Recommendation Report for Planning Permission for Works or Extension to a Dwelling

REF NO: BN/92/19/HH

LOCATION: Westray
3 Oriel Close
Barnham
PO22 0HN

PROPOSAL: Two storey side extension with new rear dormer and single storey rear extension, demolition of existing garage and new driveway with entrance gates.

19067-104⁰

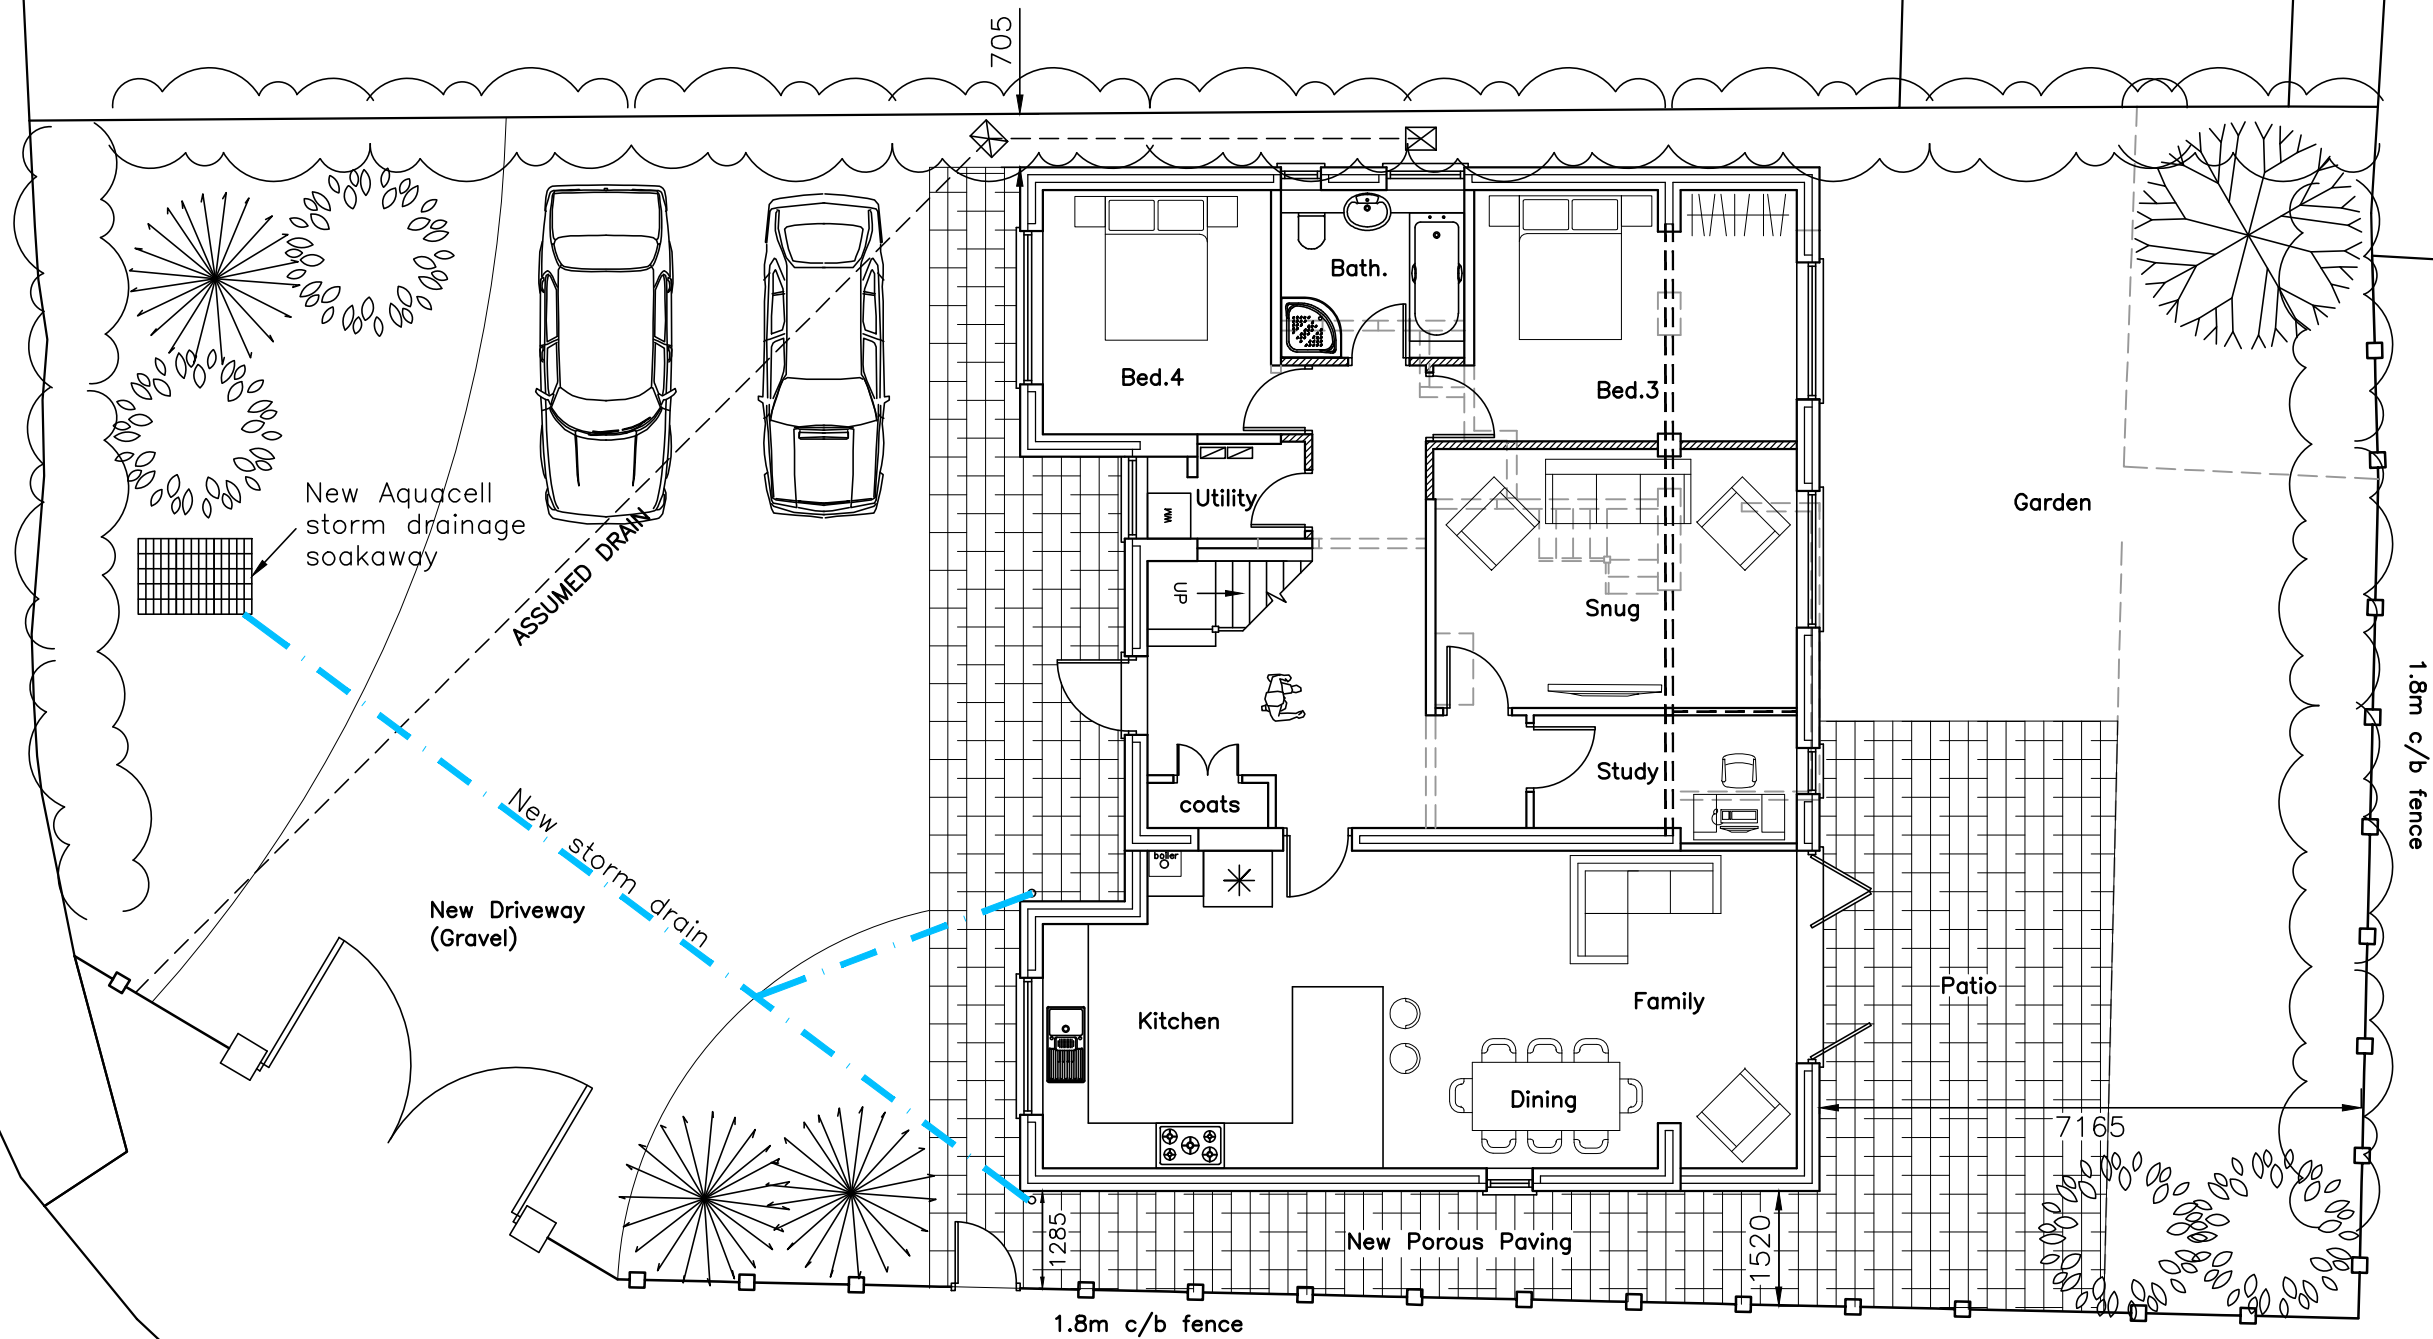
Engineers have requested a pre-commencement condition regarding drainage - the applicant has agreed. The condition will be slightly varied to allow the construction of the access/hardstanding prior to the submission of the details.

- 3 Development shall not commence, other than works of site survey and investigation and the creation of the access/hardstanding, until full details of the proposed surface water drainage scheme have been submitted to and approved in writing by the Local Planning Authority. The design should follow the hierarchy of preference for different types of surface water drainage disposal systems as set out in Approved Document H of the Building Regulations, and the recommendations of the SuDS Manual produced by CIRIA. Winter groundwater monitoring to establish highest annual ground water levels and winter Percolation testing to BRE 365, or similar approved, will be required to support the design of any Infiltration drainage. No building / No part of the extended building shall be occupied until the complete surface water drainage system serving the property has been implemented in accordance with the agreed details and the details so agreed shall be maintained in good working order in perpetuity.
